Charlotte Department of Transportation

Memorandum

Subject: Rezoning Petition 08-124: Located on the south side of East Boulevard
between South Boulevard and Cleveland
Avenue

01 SITE PLAN

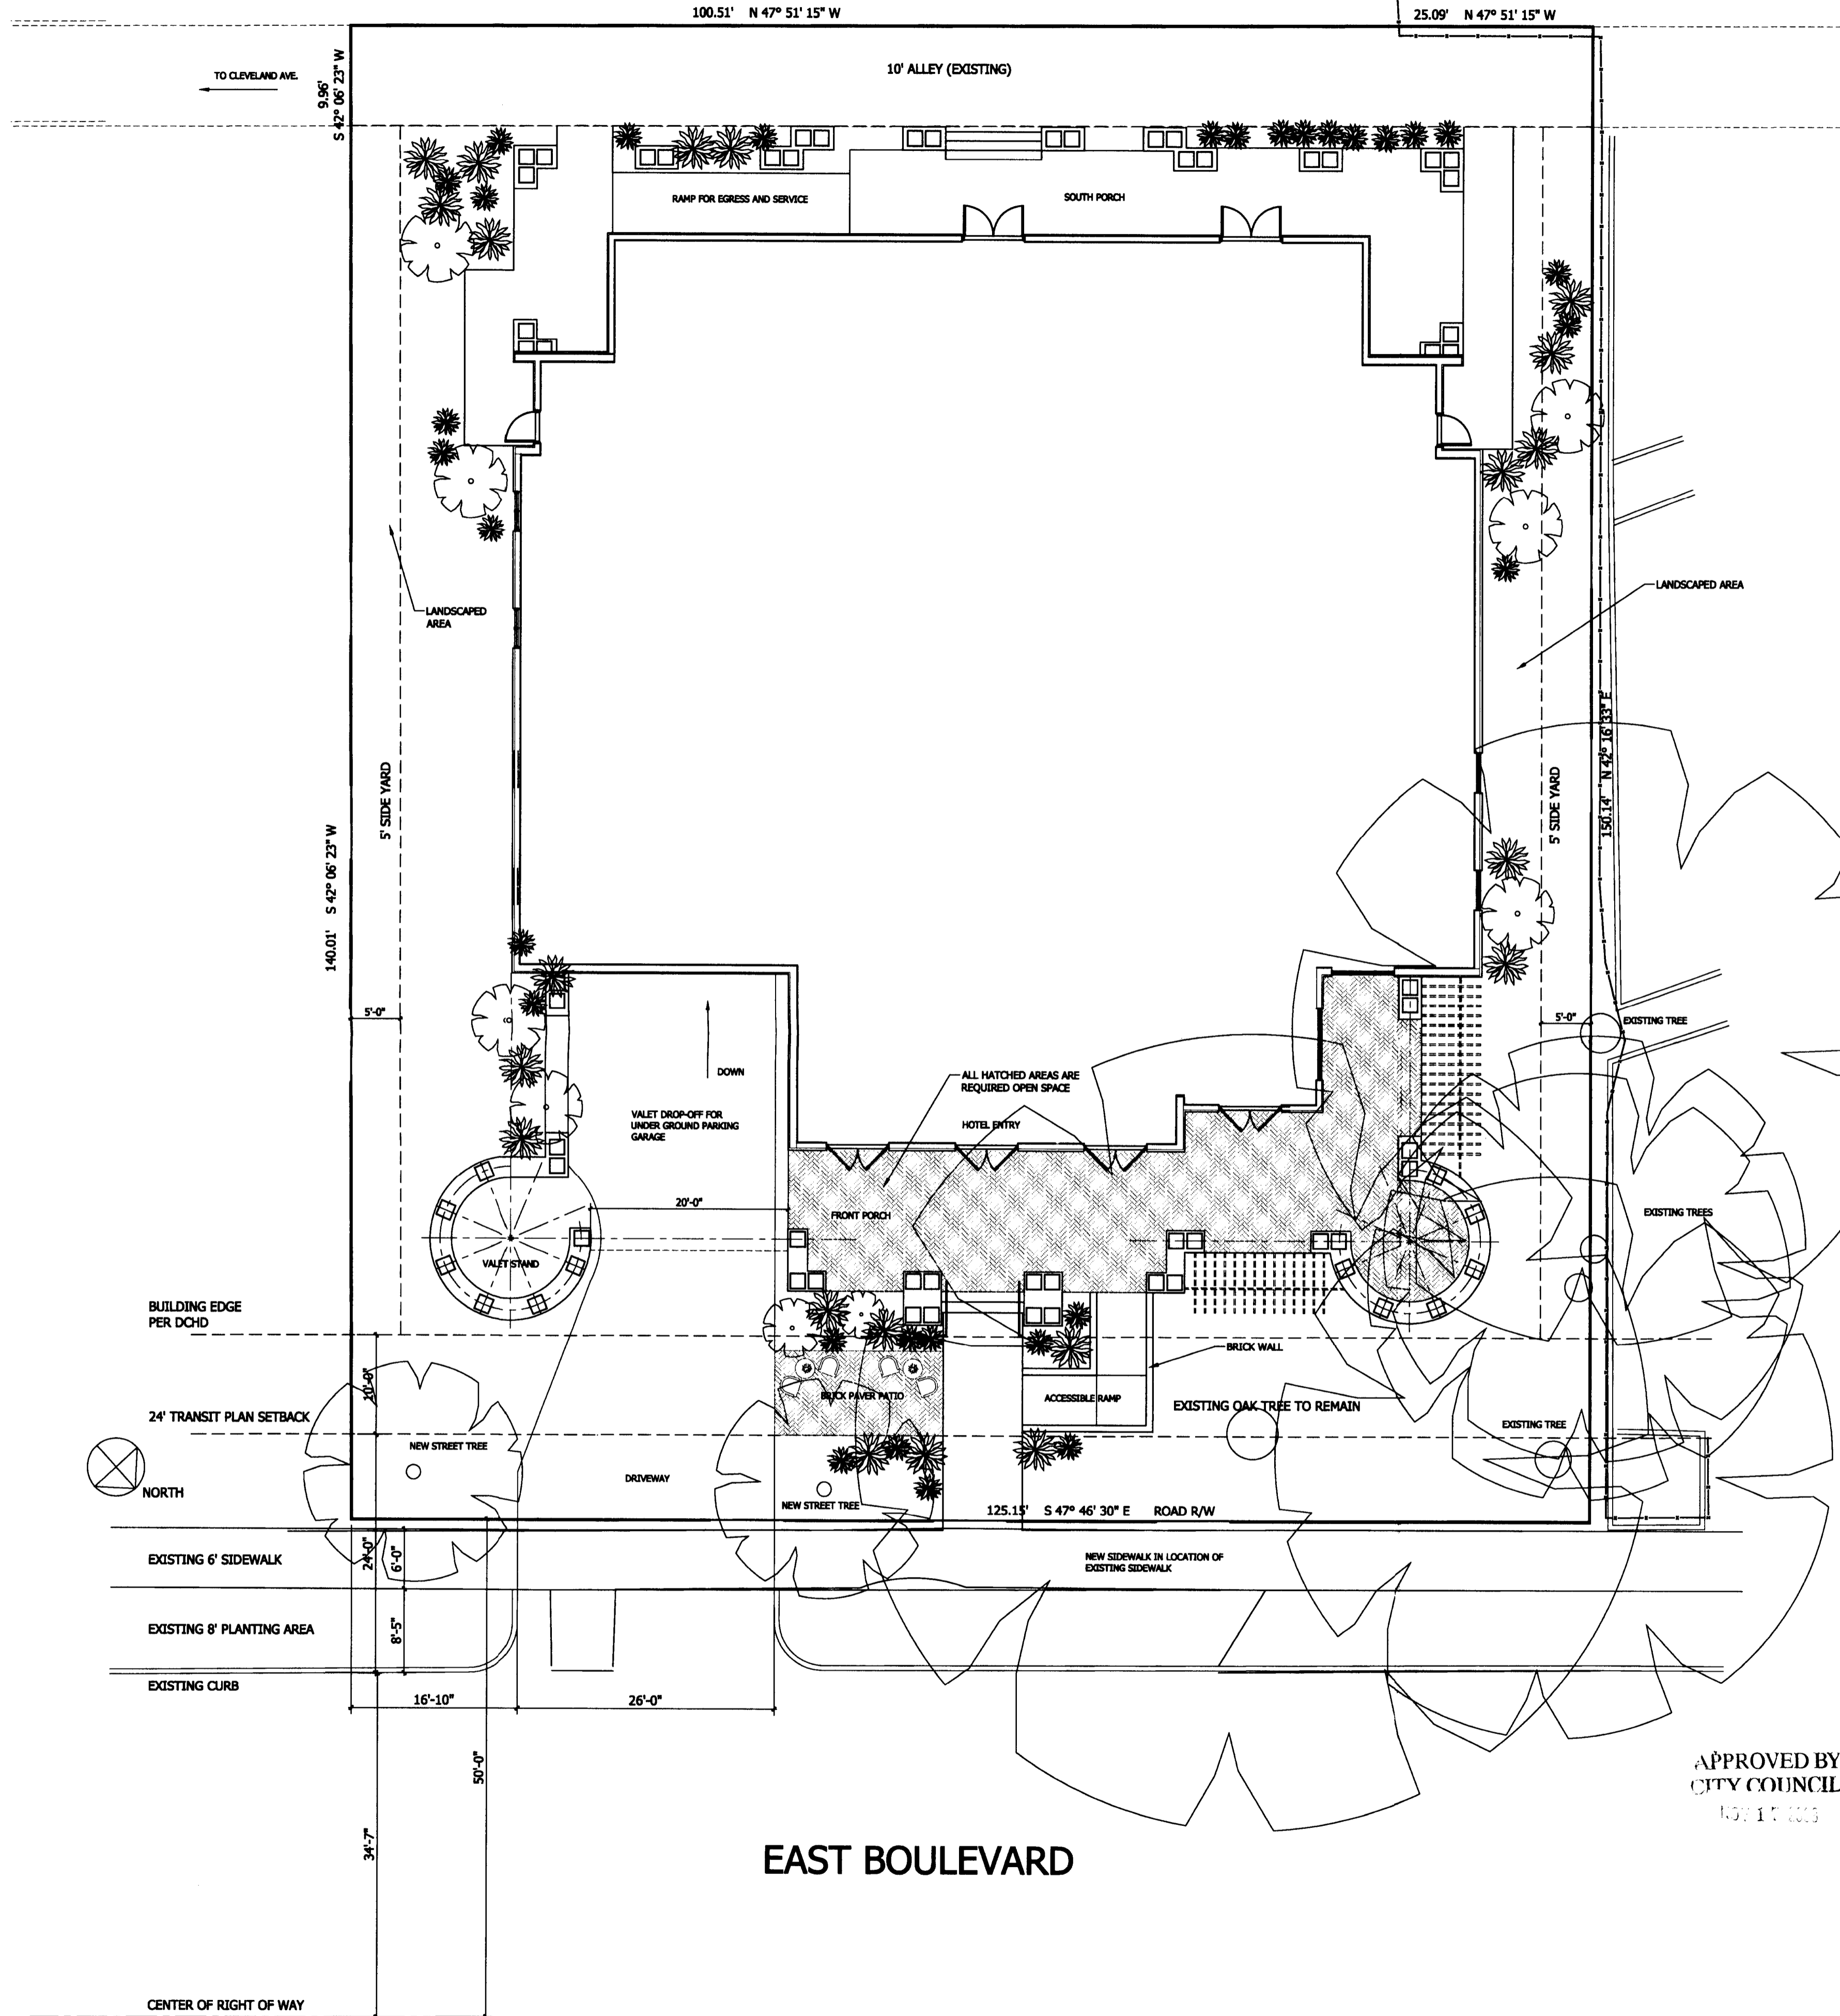
1. As provided in the South End Transit Station Area Plan, East Boulevard has an adopted new cross-section with a 53' back-of-curb width. Therefore, the TOD setback will be measured from the back of the future curb line.
2. The proposed zoning district requires 6' sidewalks and 8' planting strips along East Boulevard, as measured from the future curb line. In order to facilitate the adopted future curb line of East Boulevard, the developer may construct a wider planting strip in lieu of relocating the curb at this time.

3. The driveway will need to have a minimum offset of 10 feet from the side property line and meet the Type II- Modified (ramp type with radii) driveway design standards. The driveway accessing the parking deck will need to maintain a minimum width of 20 feet for two-way operation. As shown on the site plan, the valet stand conflicts with this requirement.
4. We are not in support of the request to eliminate the required on-site delivery/loading space. If this function is not provided on-site, then waste collection dumpsters will need to be rolled to the street for pick-up and other service deliveries to the site will also need to occur on East Boulevard.
5. The design and operation of the parking deck will be evaluated during the MUDD review process.

Adequate sight triangles must be reserved at the existing/proposed street entrance(s). Two 10-foot x 10-foot sight triangles are required for the entrance(s) to meet requirements. All proposed trees, berms, walls, fences, and/or identification signs must not interfere with sight distance at the entrance(s). Such items should be identified on the site plan.

- Meet applicable Land Development Standards (latest revision).
- Dimension width of the existing and proposed driveways.
- New/reconstructed driveways must be drop curb Type II-Modified driveways.
- Indicate the locations and widths of all adjacent and opposing driveways.
- Indicate typical parking module dimensions.
- Include a parking summary with figures for the numbers of parking spaces required and provided.
